Greenhill Solar

The following is a critique of the 'Traffic and Transport' section of the 'OCTMP' (Outline Construction Traffic Management Plan) submitted by 'KMC transport planning' on behalf of Greenhill Solar Farm

Issues ref - Traffic and transport (Areas C,D and E)

Title:
Figure 13.15: Access Locations for Sites and
Cable Route Corridor (South Area Part 1)

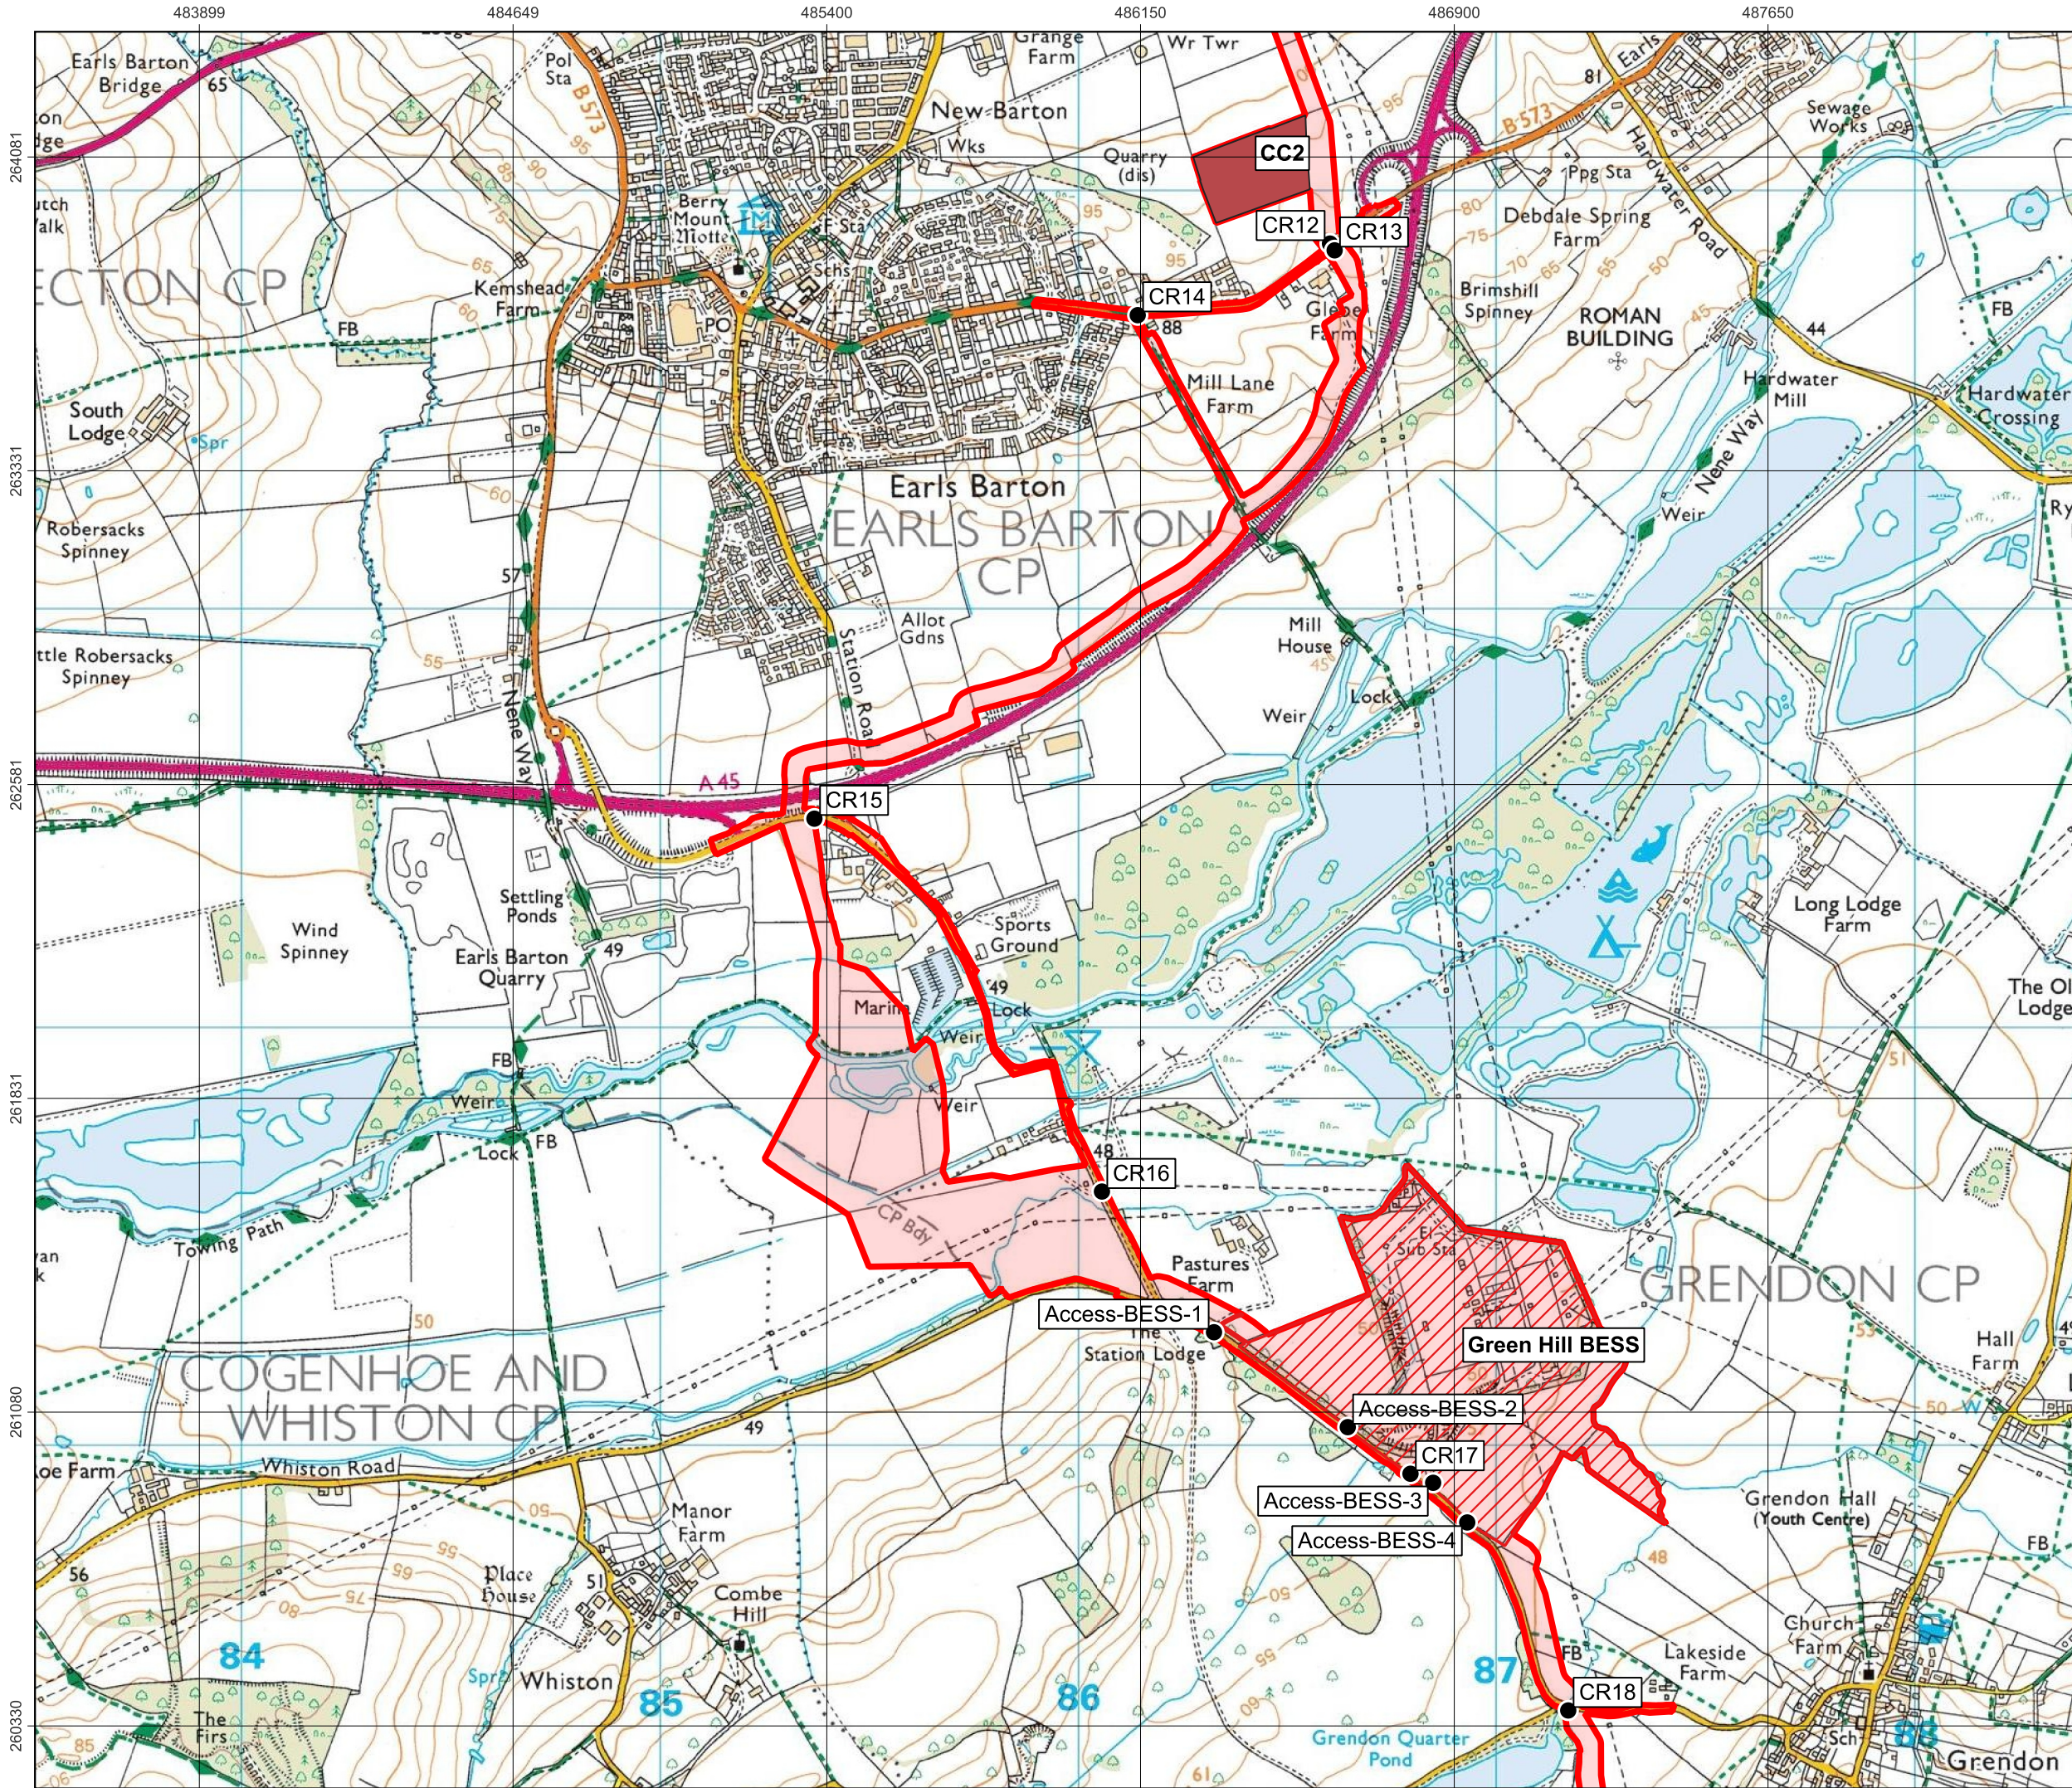
Below is the proposed Access D1-right on the junction of Sywell road, which is a busy commuter road. Creation of an access here will be difficult and dangerous.

That being the case then there will be 4/5 sets of traffic lights on Highfield Road. This would be traffic chaos and should really be subject to a road closure. Given that the alternative is Glebe Road, which is single track, then this exemplifies the fact that this fragmented solar farm proposal, is totally unsuitable for this location

For the main access on Sywell road, (C1 opposite Beckworth Emporium) 4 way temporary traffic lights will be required at the junction to control traffic from both directions east west and for access into area C and to access to Glebe road and the entrance to Beckworth Emporium 20m from the junction.
